**WELWYN HATFIELD BOROUGH COUNCIL
EXECUTIVE DIRECTOR - PLANNING, PUBLIC PROTECTION AND GOVERNANCE**

DELEGATED APPLICATION

Application No: 6/2022/1508/HOUSE
Location: The Lodge 2 Northaw Place Coopers Lane Northaw Potters Bar
 Hertfordshire EN6 4NQ
Proposal: Erection of a two storey side extension
Officer: Ms Kirsty Shirley

Recommendation: Refused

Title:  
**Floor Plans  
 as Proposed**

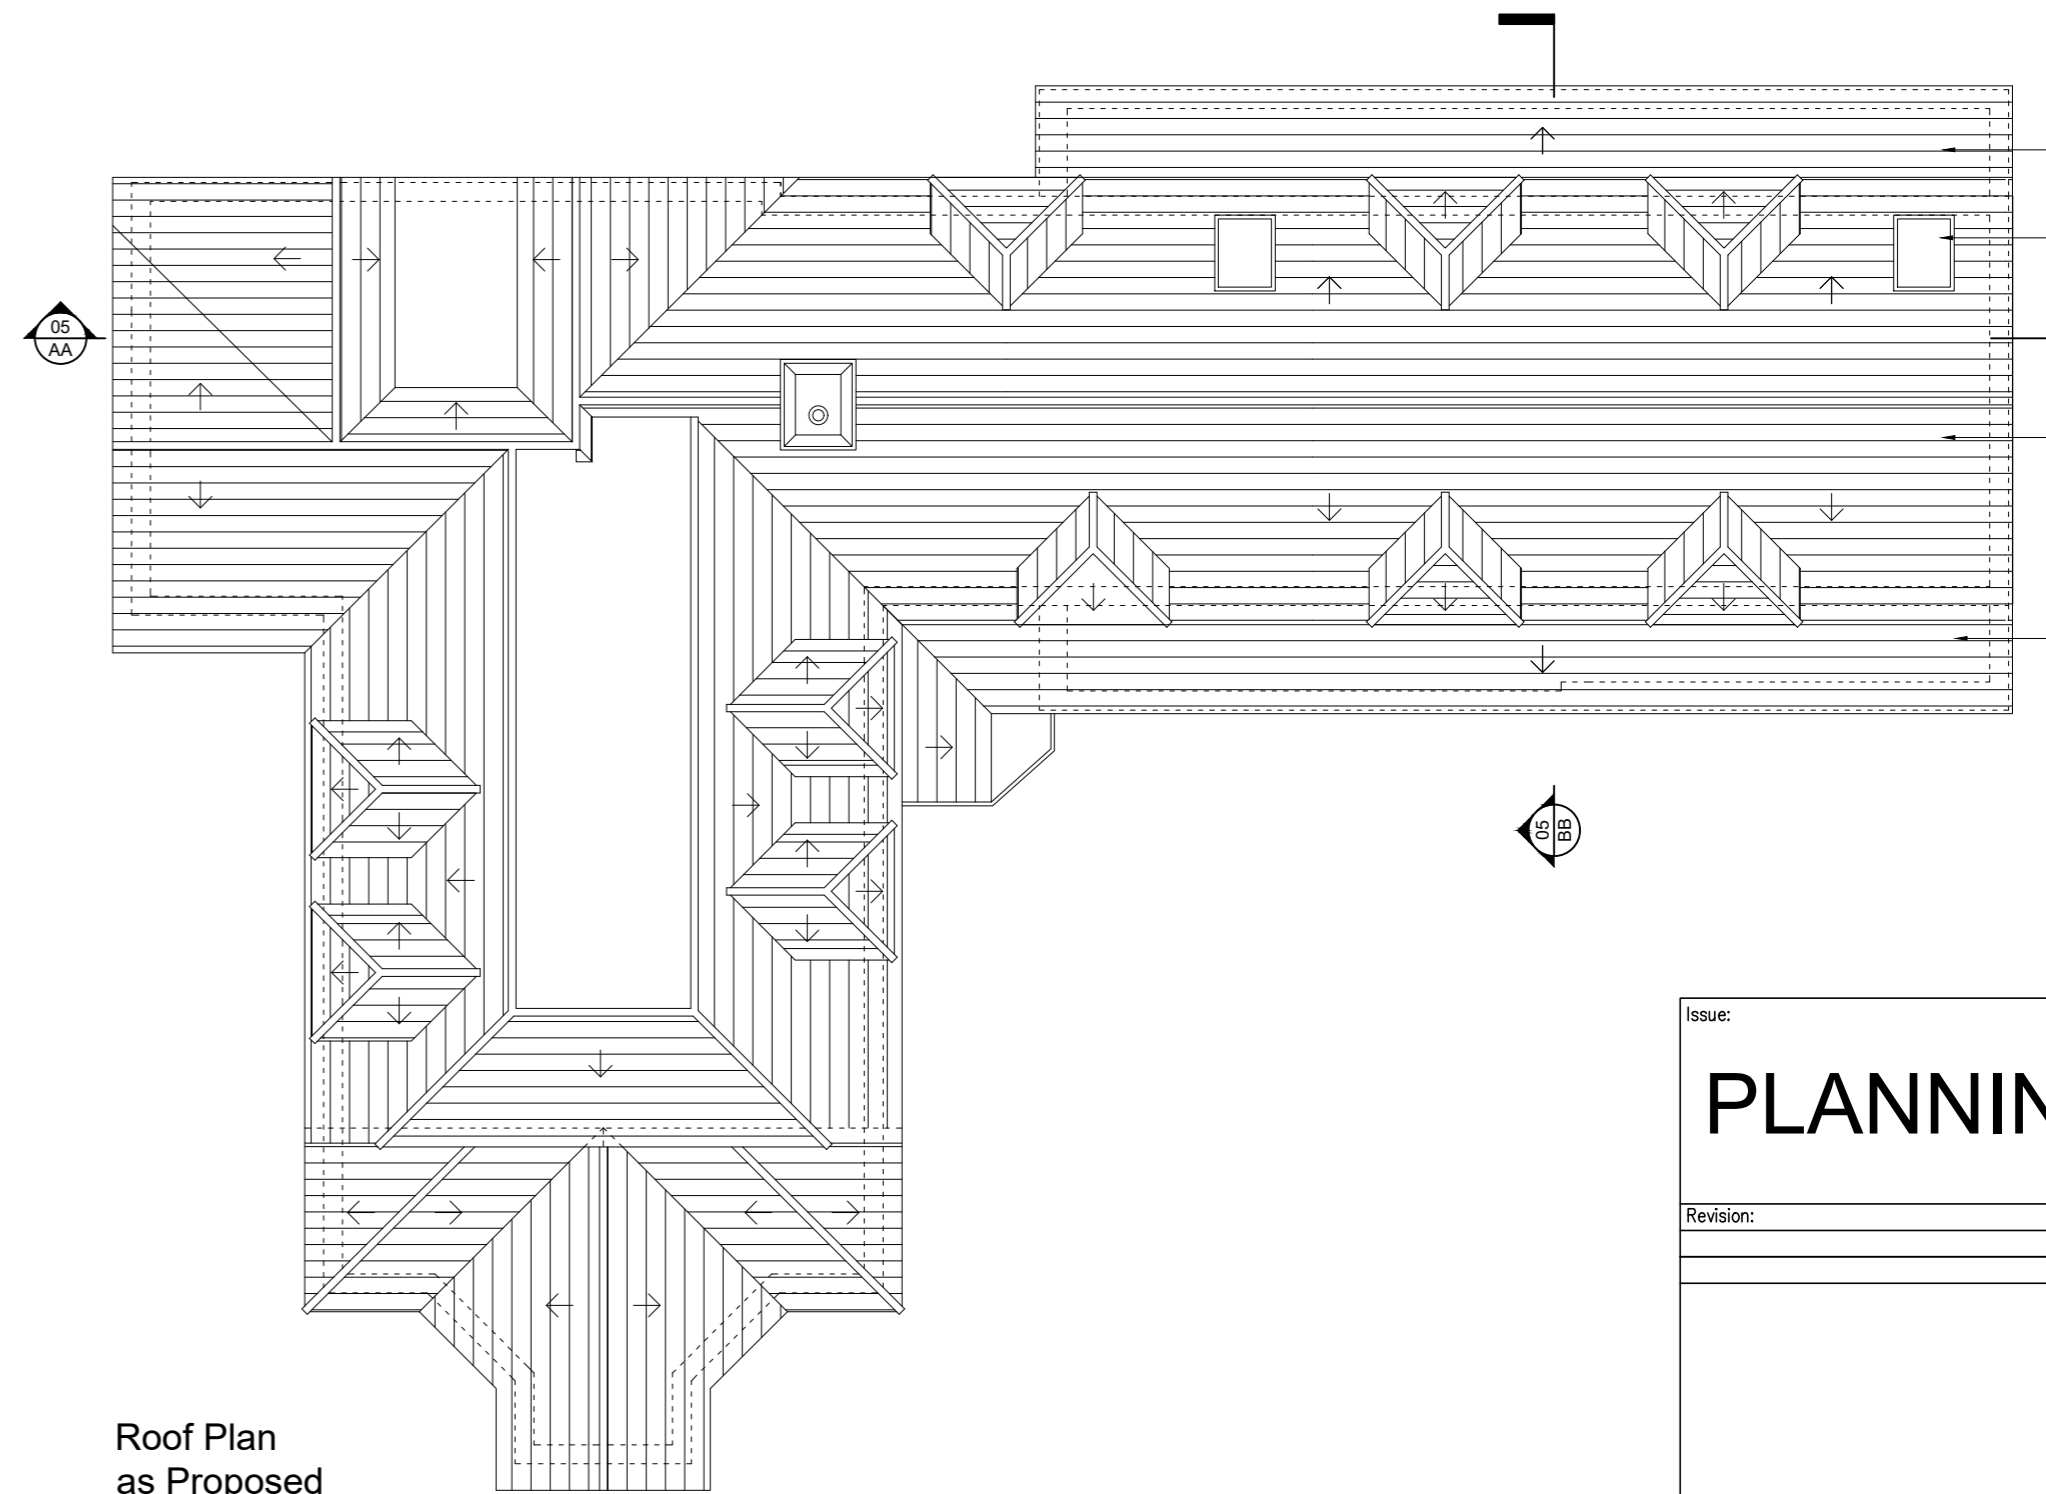
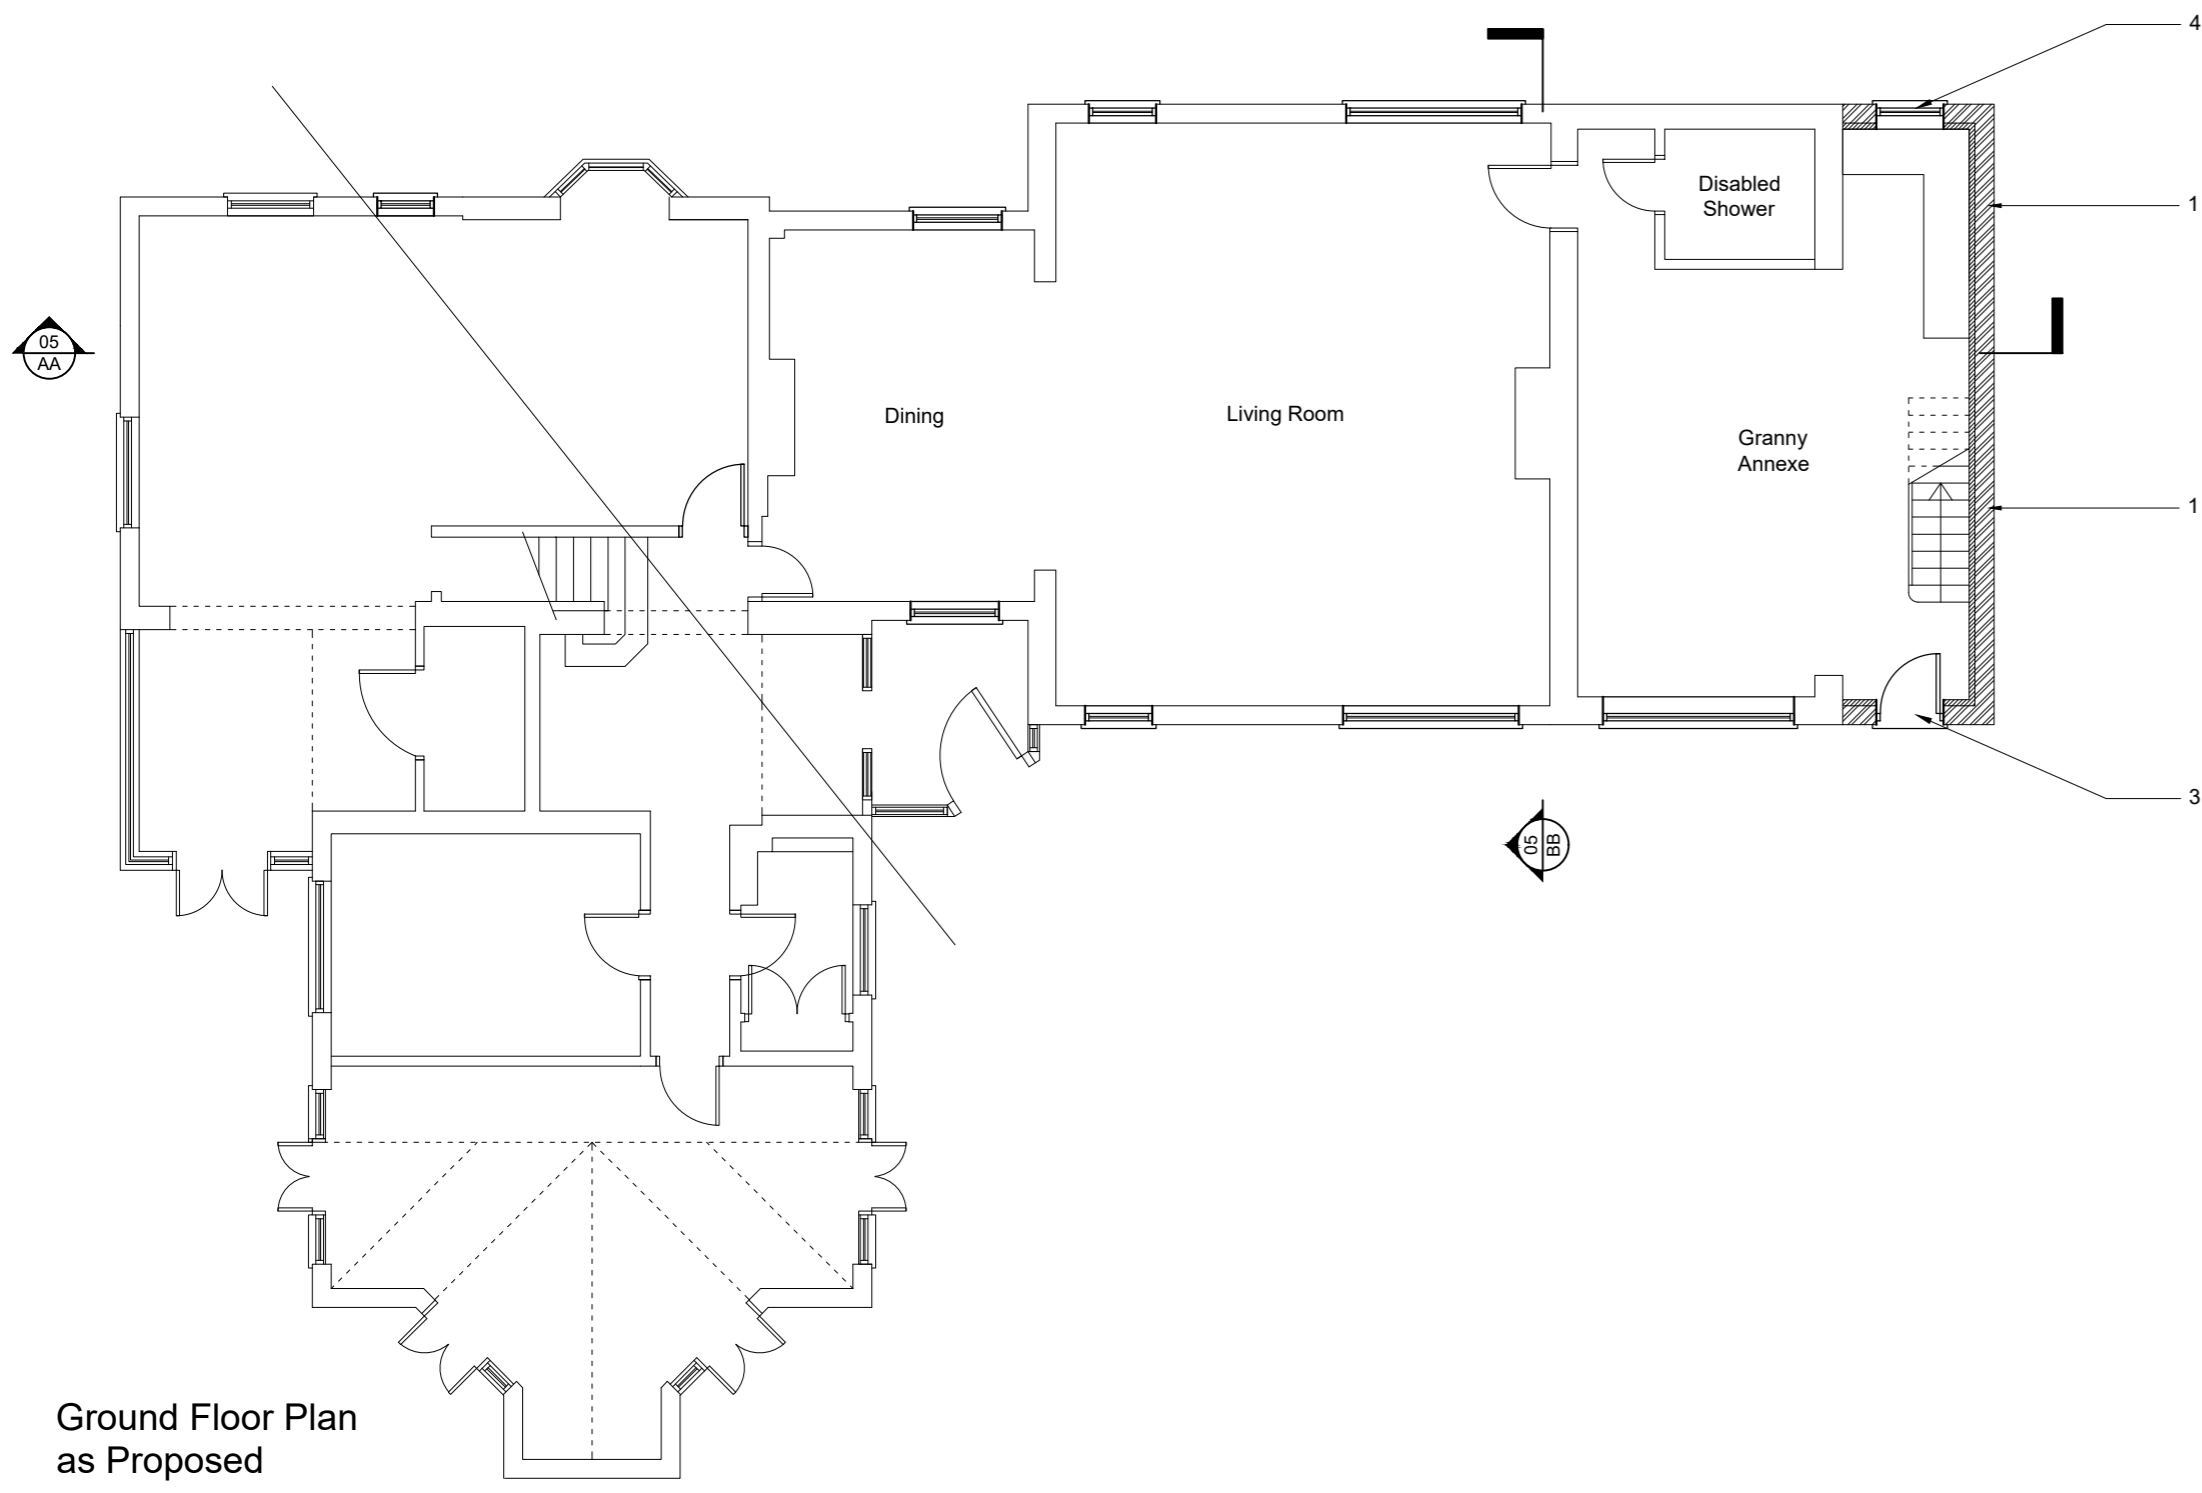
The application site has been extended and altered over many years. The Local Planning Authority considers that the floor space of the original property was approximately 198m². Additions to the property have resulted in a considerable increase in the overall floorspace of the dwelling so that it is now in excess of 300m², resulting in a floor area that has been increased by over 65% when compared to that of the original building. This application is for the erection of a two storey side extension, which would add approximately 16.5m² to the footprint of the dwelling and approximately 57.8m² in first floor floorspace. As already stated, the current dwelling is already in excess of 65% larger than the original, and so any further increase in floor space on the site will increase this percentage further. The proposed floor area as a result of the development would be approximately 443m², representing an increase of approximately 123.7% from the original floor space, which excludes other development within the site such as the detached garage. Having regard to all of the above, it is considered that the proposal would amount to a disproportionate increase to the size of the existing dwelling.

In terms of a qualitative assessment, the proposed extension would result in substantial bulk and massing to the existing dwelling, predominantly at first floor level.

<p>increase the size of the dwelling, notably at first floor level. The development would introduce built form in an area which currently provides open space, resulting in a material loss of Green Belt openness in spatial terms.</p>
<p>Design (form, size, scale, siting) and Character (appearance within the streetscene)</p>	<p>District Plan Policy GBSP2 notes that development within the specified settlements will be limited to that which is compatible with the maintenance and enhancement of their character. Policies D1 and D2 require the standard of design in all new development to be of a high quality and that all new development respects and relates to the character and context of the area in which it is proposed, maintaining and where possible enhancing the character of the existing area. These policies are expanded upon in the Council's Supplementary Design Guidance (SDG) which requires the impact of a development to be assessed giving regard to the bulk, scale and design of the proposal and how it harmonises with the existing building and area.</p> <p>In terms of the character of the area, paragraph 2.4 of the SDG outlines, amongst other things, that new development should:</p> <ul style="list-style-type: none"> - Respond to building forms and patterns of existing buildings in the detailed layout and design to reinforce a sense of place; - Use local materials and building methods/details to enhance local distinctiveness; and - Ensure that the scale, height, massing, and space around the new development in relation to the adjoining buildings is considered <p>The revised National Planning Policy Framework (NPPF) has a stronger emphasis on good quality design than its predecessor. Paragraph 126 clearly advises that the creation of high quality, beautiful and sustainable buildings and places is fundamental to what the planning and development process should achieve and that good design is a key aspect of sustainable development. Paragraph 130 of the NPPF further advises that decisions should ensure developments will function well and add to the overall character of the area, be visually attractive, sympathetic to local character and establish a strong sense of place. Paragraph 134 is clear that <i>“Development that is not well designed should be refused, especially where it fails to reflect local design policies and government guidance on design, taking into account any local design guidance and supplementary planning documents such as design guides..”</i></p> <p>The first floor extension would continue from the ridge height of the dwelling and would extend across, and over, the current single storey element of the dwelling, adding additional footprint to the ground floor of the dwelling. The extension would feature a gable roof in keeping with the roof form it would extend from, as well as featuring dormer windows that would match the existing dormers within the roof of the dwelling.</p> <p>The size and scale of the proposed extension would be a substantial increase to the existing dwelling. The increase in size would be particularly noticeable given the additional bulk and massing would be at first floor level. While the dwelling is mostly screened from view of the street scene, by virtue of fencing and vegetation, partial views of the development would be visible from the street scene due to the scale and positioning of the extension, detracting from the character of the area.</p>

<p>Access, car parking and highway considerations</p>	<p>The development would add an additional two bedrooms within the application dwelling. The site benefits from a detached garage and a sizeable driveway that can accommodate parking for many vehicles. The development therefore retains adequate on-site car parking provision.</p>
<p>Conclusion</p>	
<p>The proposed development, which is located within land designated as Metropolitan Green Belt, would constitute inappropriate development and is therefore by definition harmful development. In addition to this harm, there would also be harm to the openness of the Green Belt. No very special circumstances exist which outweigh the harm to the Green Belt. Consequently the proposed development would conflict with Policies GBSP1 and RA3 of the Welwyn Hatfield District Plan; Policy SADM34 of the Emerging Local Plan; and the National Planning Policy Framework.</p> <p>Furthermore, the proposed development, by virtue of the extensions positioning, size and scale, would result in unduly dominant and overbearing additions to the dwelling that would fail to complement and reflect the design and appearance of the application dwelling. Accordingly, the proposed development represents a poor standard of design which is harmful to the appearance of the application dwelling and the character of the area, contrary to Policies D1 and D2 of the Welwyn Hatfield District Plan; Policies SP9 and SADM11 of the Emerging Local Plan; the Supplementary Design Guidance; and the National Planning Policy Framework.</p>

Title:
**Elevations and Sections
as Proposed**

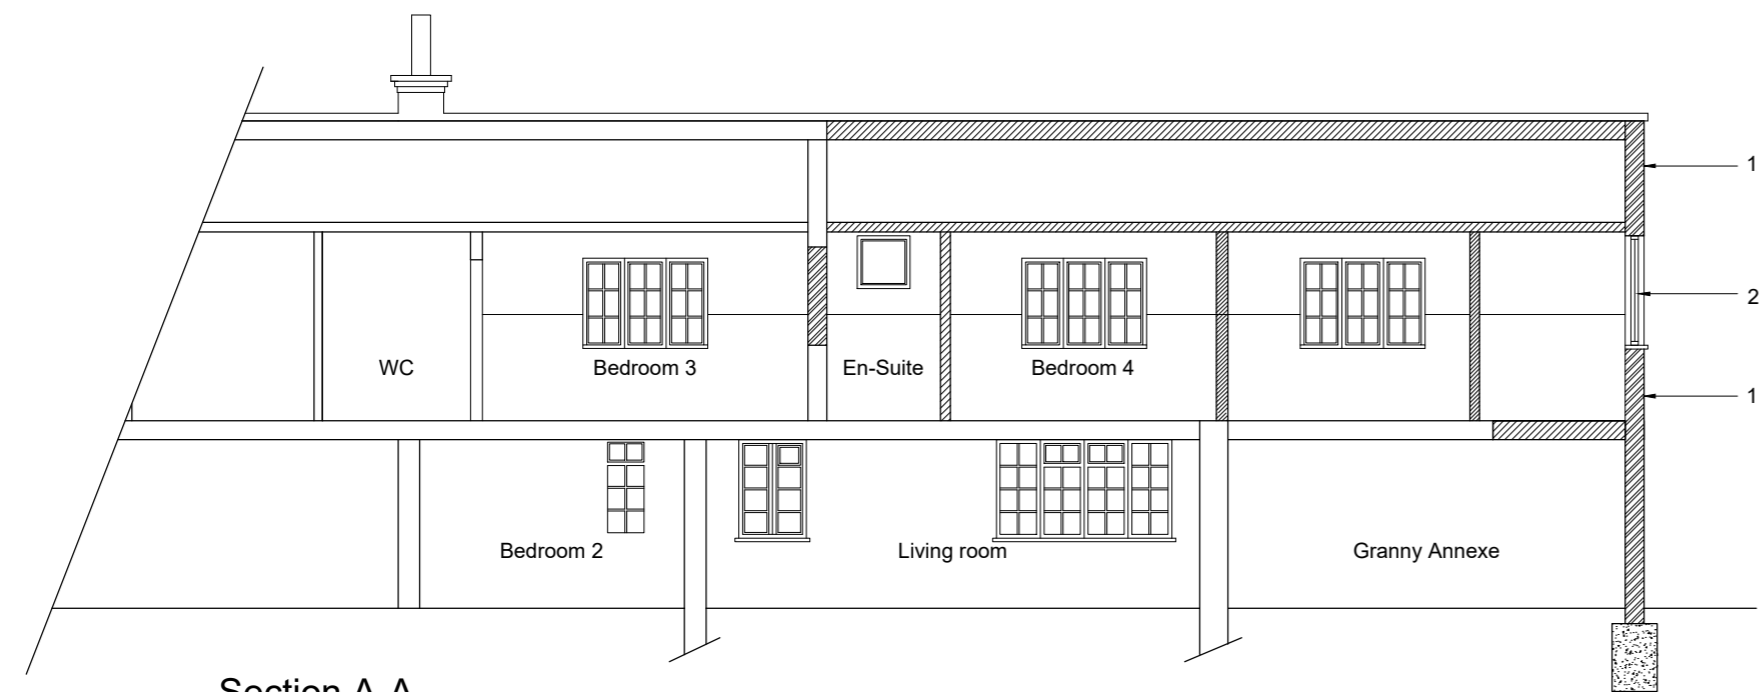
<p>It is therefore considered that the proposed development, by virtue of the extensions positioning, size and scale, would result in unduly dominant and overbearing additions to the dwelling that would fail to complement and reflect the design and appearance of the application dwelling. Accordingly, the proposed development represents a poor standard of design which is harmful to the appearance of the application dwelling and the character of the area, contrary to Policies D1 and D2 of the Welwyn Hatfield District Plan; Policies SP9 and SADM11 of the Emerging Local Plan; the Supplementary Design Guidance; and the National Planning Policy Framework.</p>
<p>Impact on neighbours</p>	<p>One objection has been received from No. 1 Northaw Place with concerns regarding the scale of development and privacy. Concerns regarding the scale of the development have been addressed earlier in the report.</p> <p>In regards to privacy, the nearest property to the application site is located on the other side of Coopers Lane, approximately 20m from the application site. No. 1 Northaw Place is located approximately 95m from the application site. The application site also benefits from vegetative screening, and in combination with substantial distances between the nearest properties, it is considered that the proposed development would not result in a loss of privacy to the occupiers of nearby properties. Similarly, such distancing would not result in nearest properties to experience a detrimental loss of sunlight nor would the development appear overbearing or unduly dominant to properties in proximity to the application site.</p>
